**RE: Legacy NAA Apartments 2  
Conceptual Grading and Drainage Plan  
Engineer's Stamp Date: 7/16/18  
Hydrology File: C18D083**

Based on the resubmittal received 7/16/2018, the Conceptual Grading and Drainage Plan is approved for action by the DRB on the Site Plan for Building Permit.

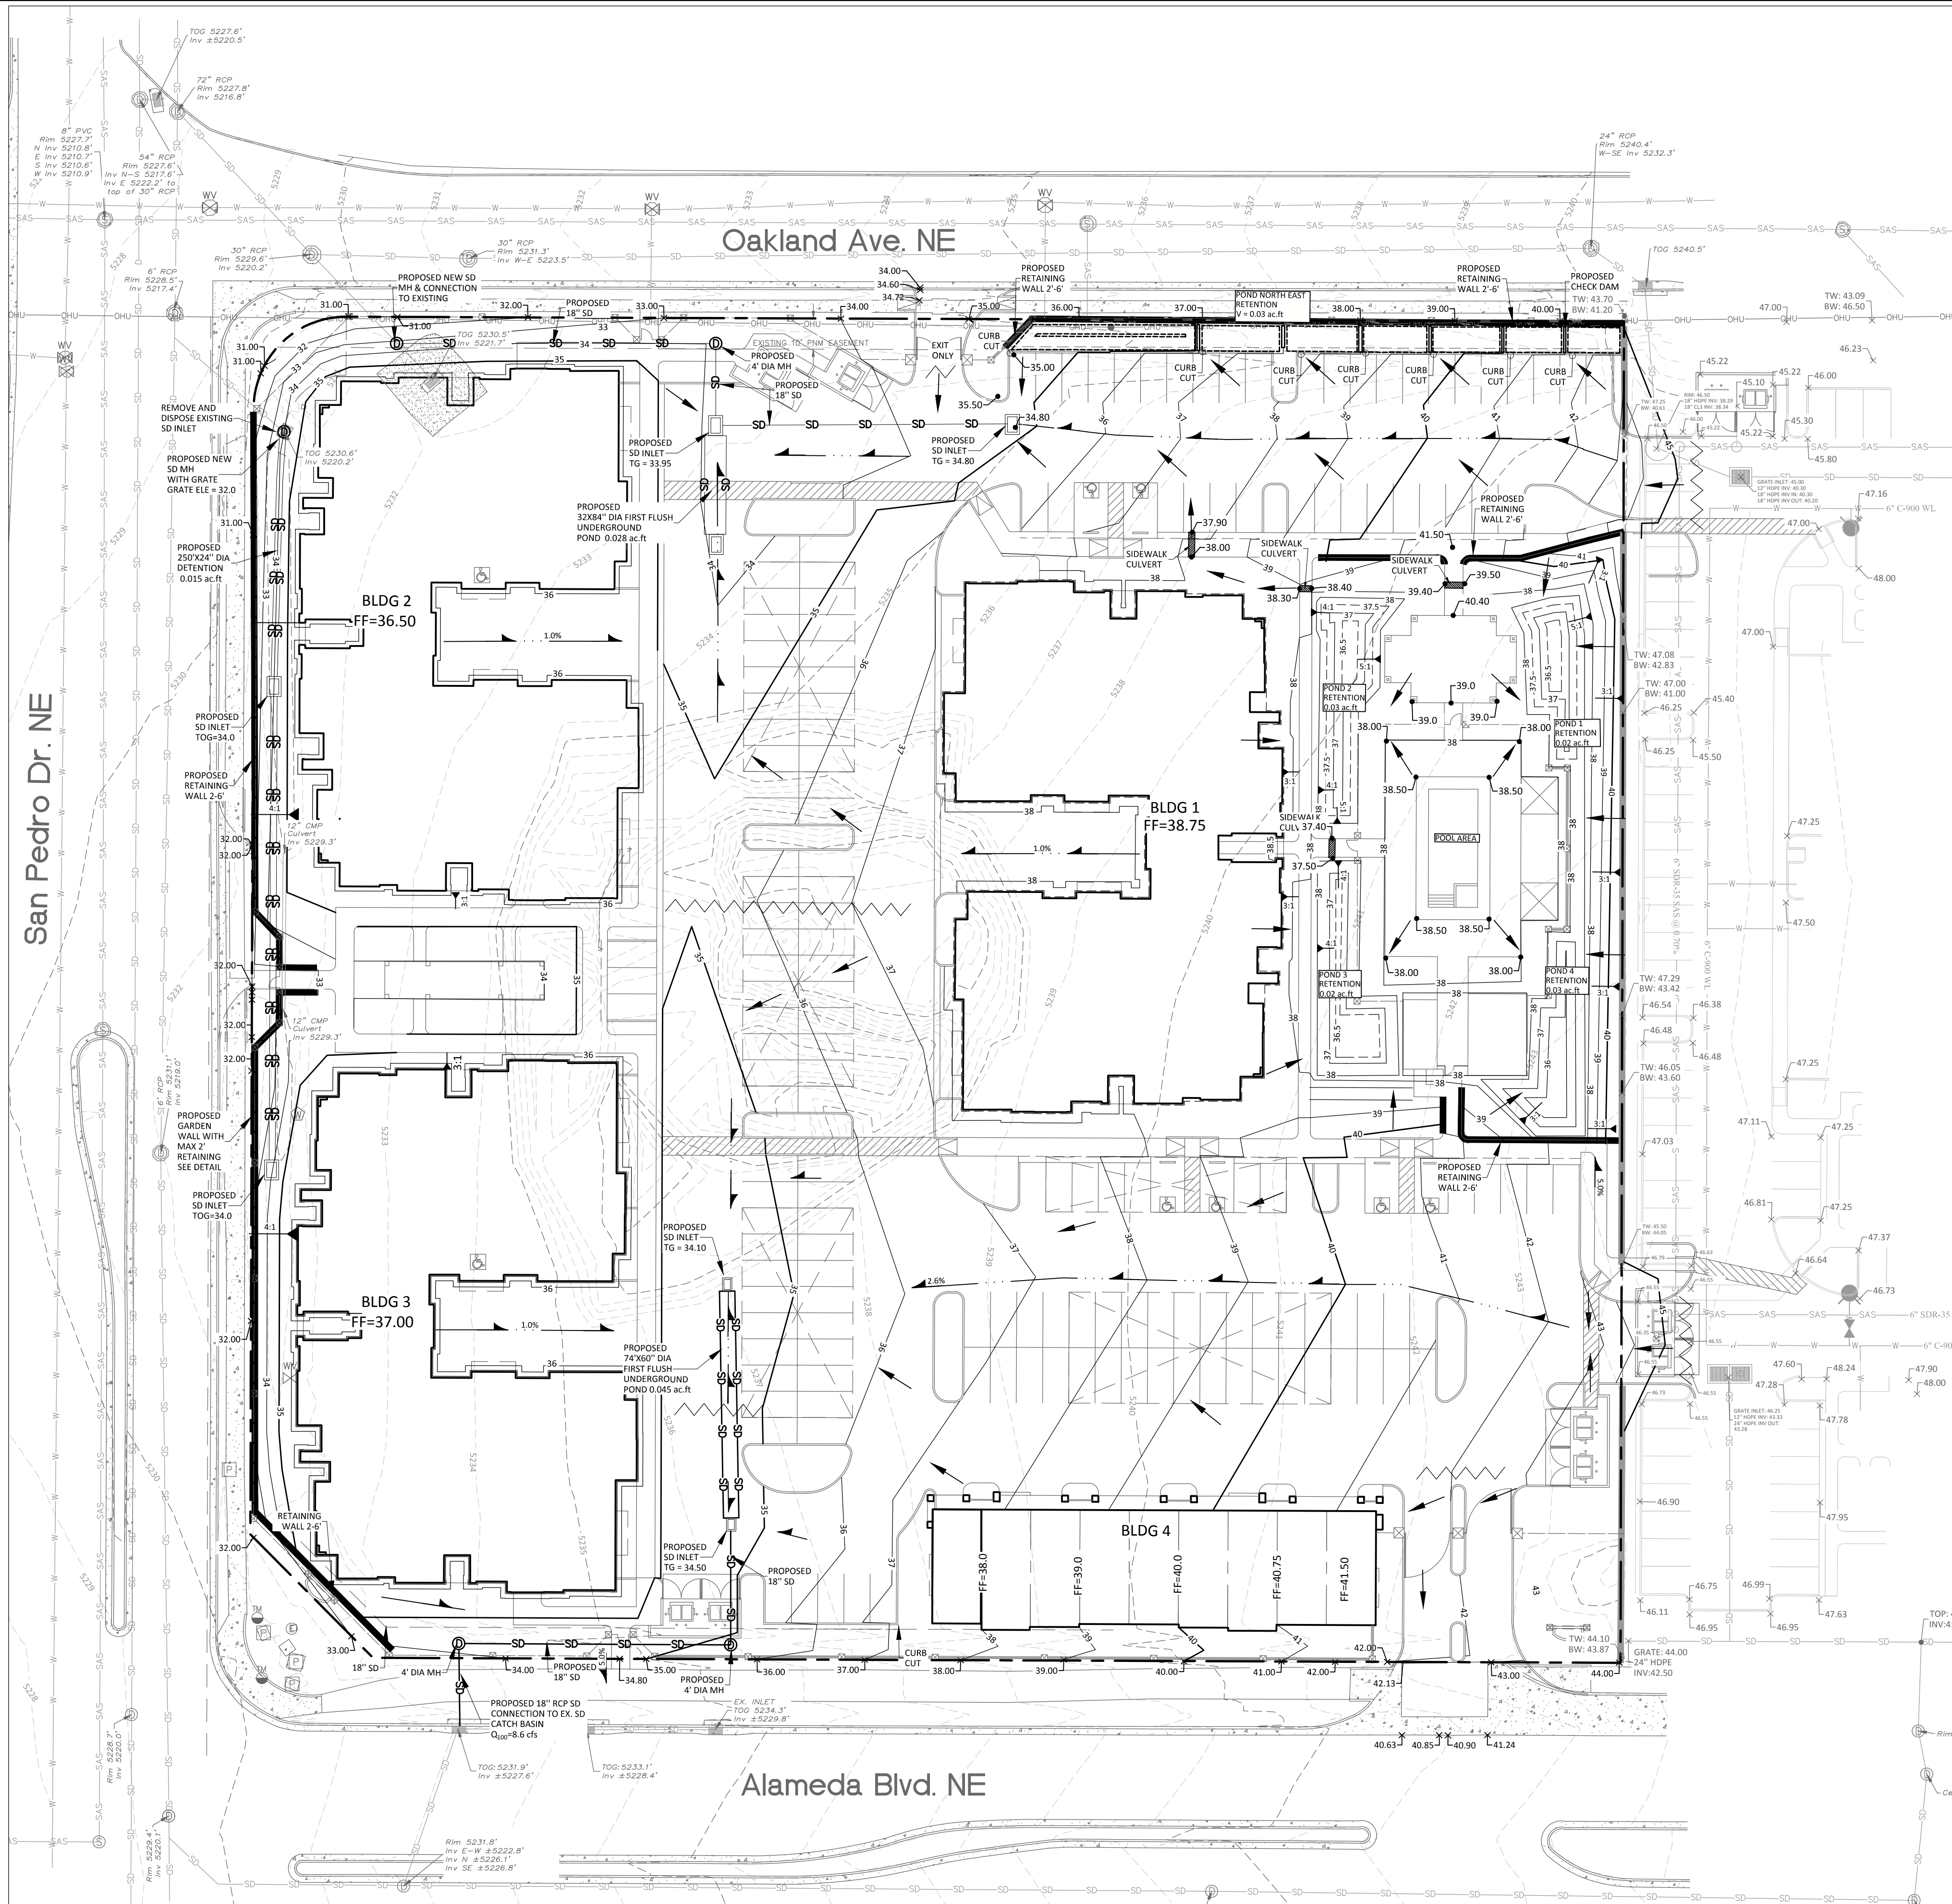
1. Please provide a Private Facility Drainage Covenant per Chapter 17 of the DPM for the first flush ponds and the retention ponds prior to Building Permit approval.
2. Correct the orifice plate size (0.80") and provide its supporting calculations.
3. Additional comments may be provided at Building Permit, based on the outcome of the above remarks and level of detail shown on plans.
